Subject: Land North of and South of Railway/Courtwick Lane, Littlehampton.

Planning Application LU/282/17/RES - observations and objections.

COURTWICK, LITTLEHAMPTON
Changing Facilities

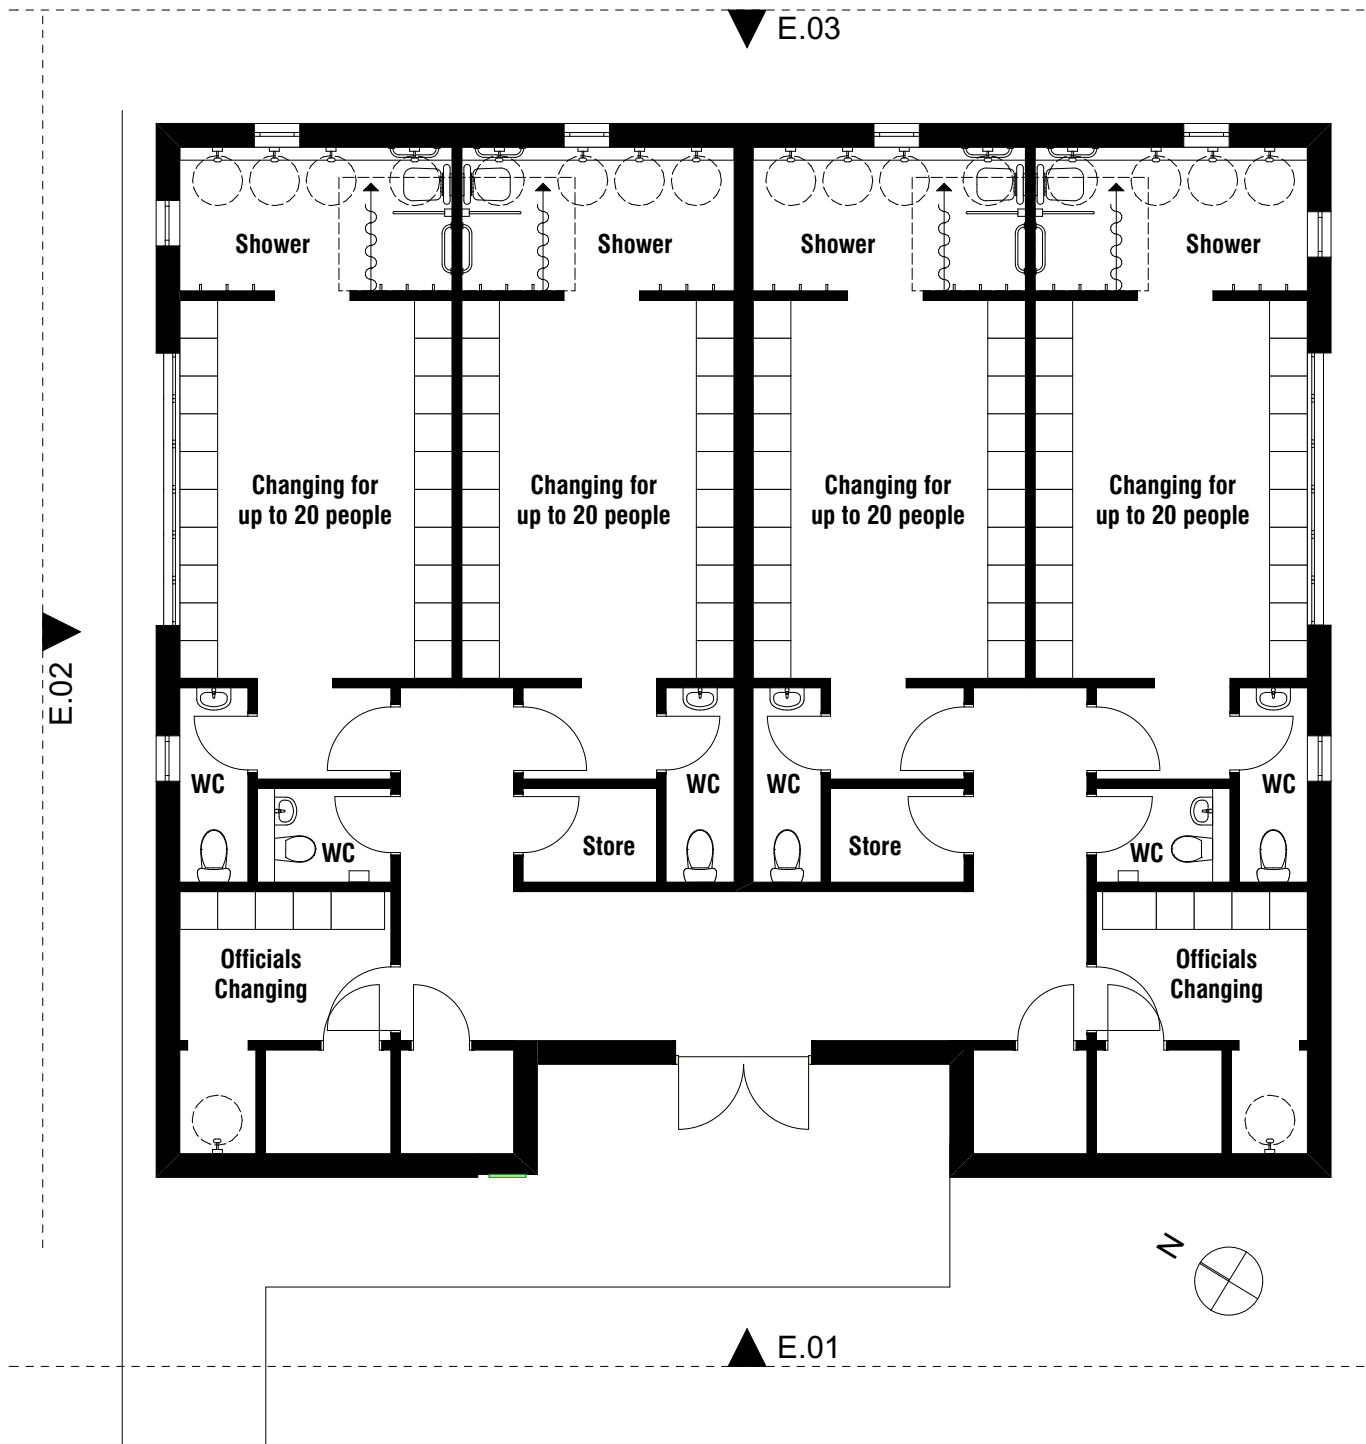
Sports Field/Facilities - The original concept for Kingley Gate was the provision of one building providing a Community Centre and changing facilities. The current application is for two separate buildings - **the sports facility building** shows potential changing for up to 80 people plus extra for officials. 100 people using the sports facility at one time plus spectators. Parking provided, according to the application covering letter, is for approximately 20 cars on 'grasscrete' - **where would the other 100 cars/coaches park?**

TITLE
COURTWICK, LITTLEHAMPTON
Block Plan

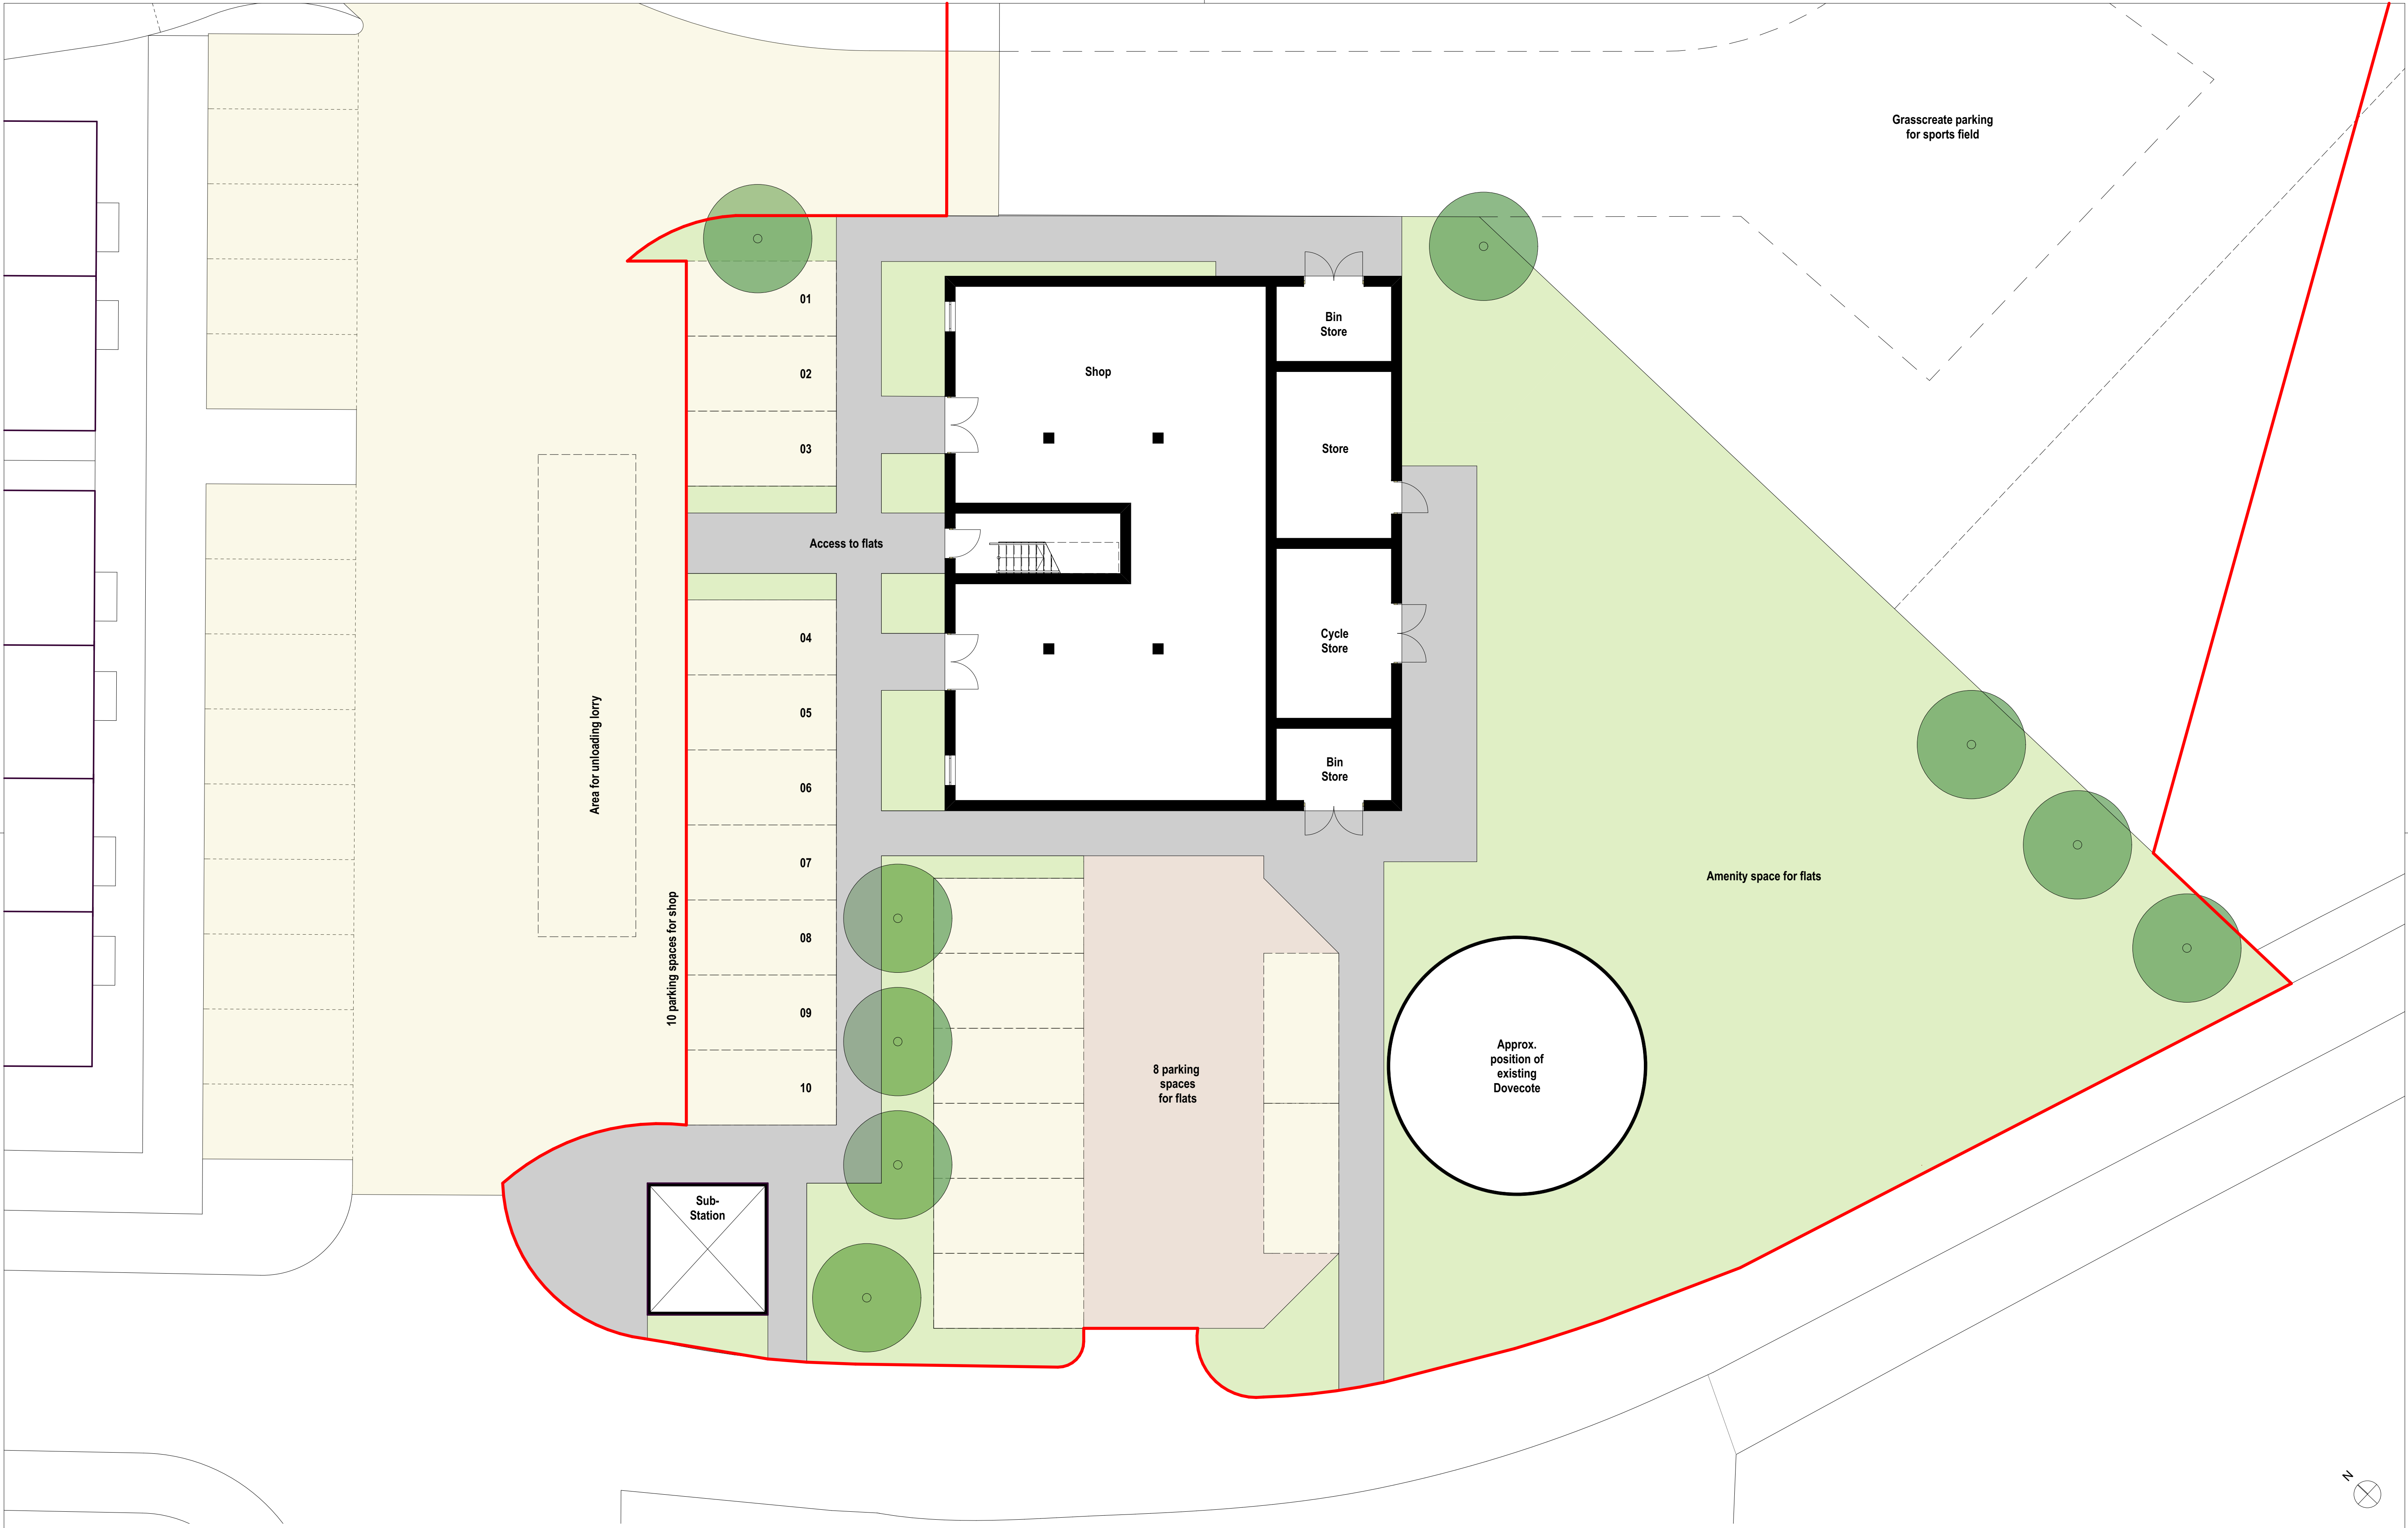
Shop/Flats/Parking - The Site Plan drawing accompanying the above application is incorrect and out of date. It shows 8 properties and 14 parking spaces within the vicinity of the shops and flats. No staff facilities or toilets are shown for the shop.

The Barratt site plan on their web site shows 10 properties and 16 parking spaces, plus a further 8 properties approved on application LU/24/17PL.

TITLE  
COURTWICK, LITTLEHAMPTON  
Commercial and Flats

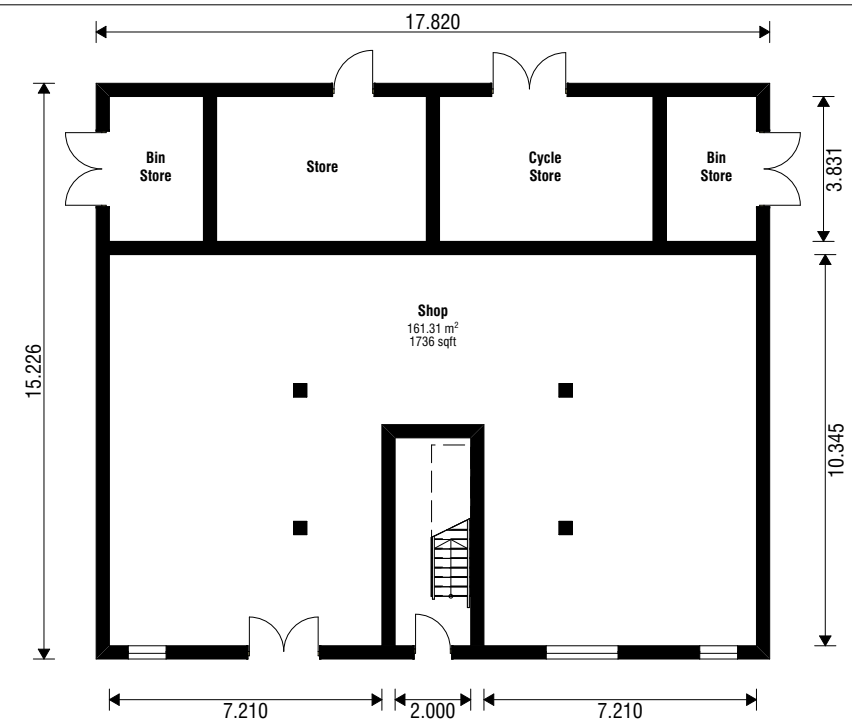
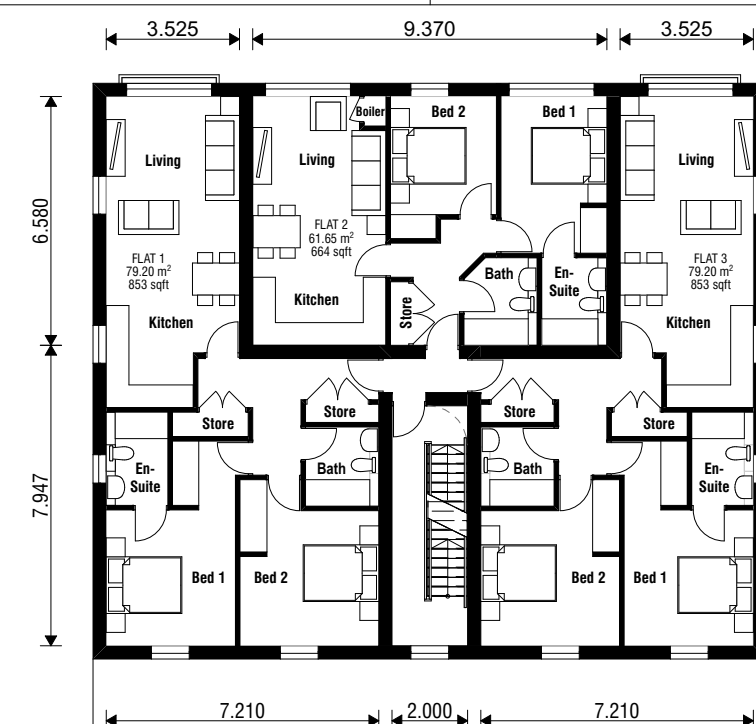
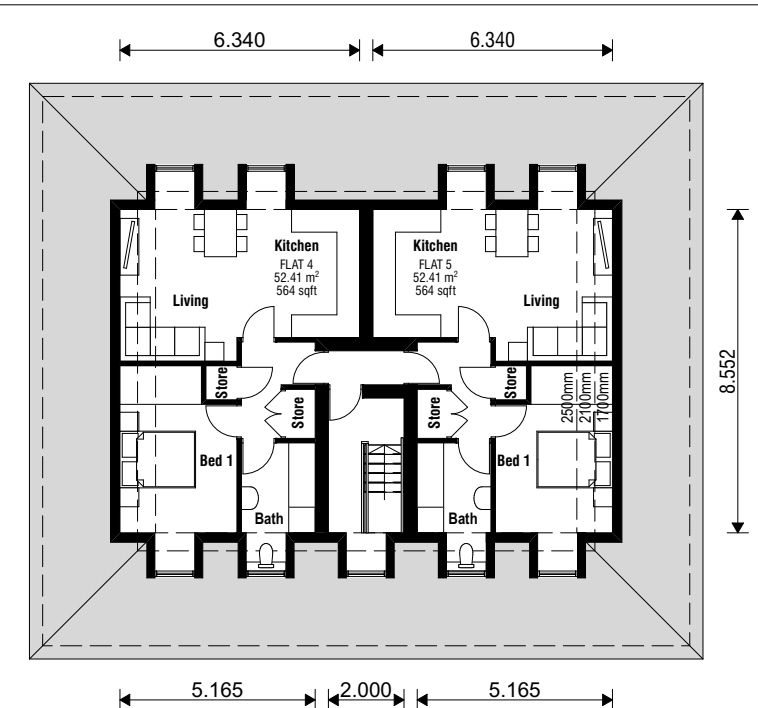
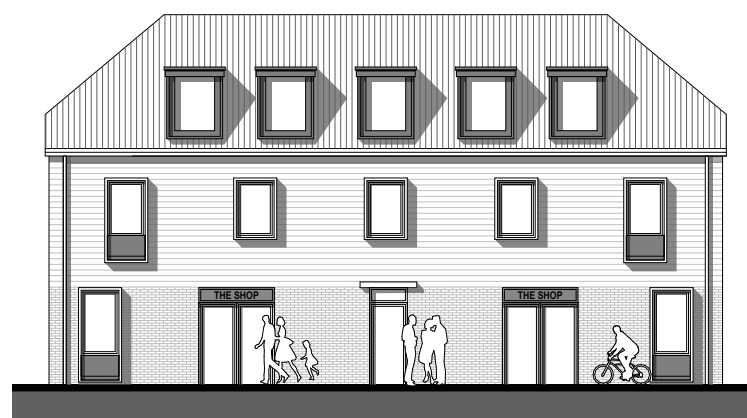
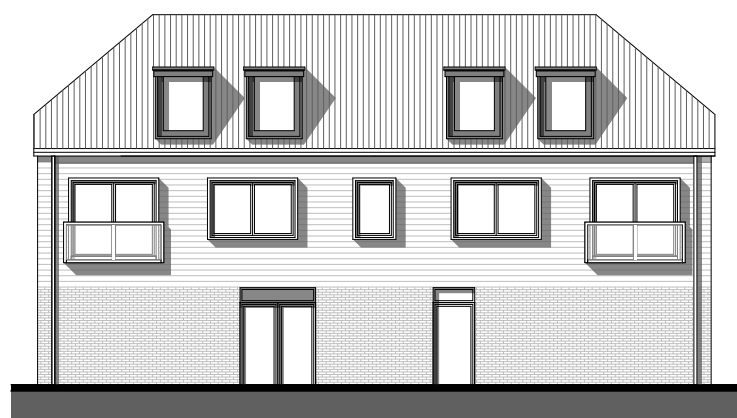
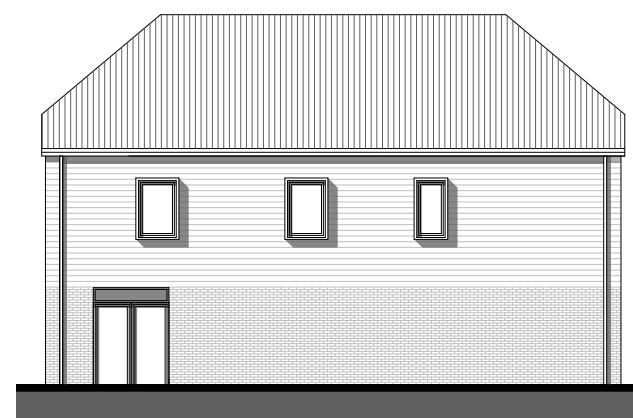
Design of the proposed shop/flats is out of keeping with the surrounding properties on the existing approved development and parking facilities inadequate.
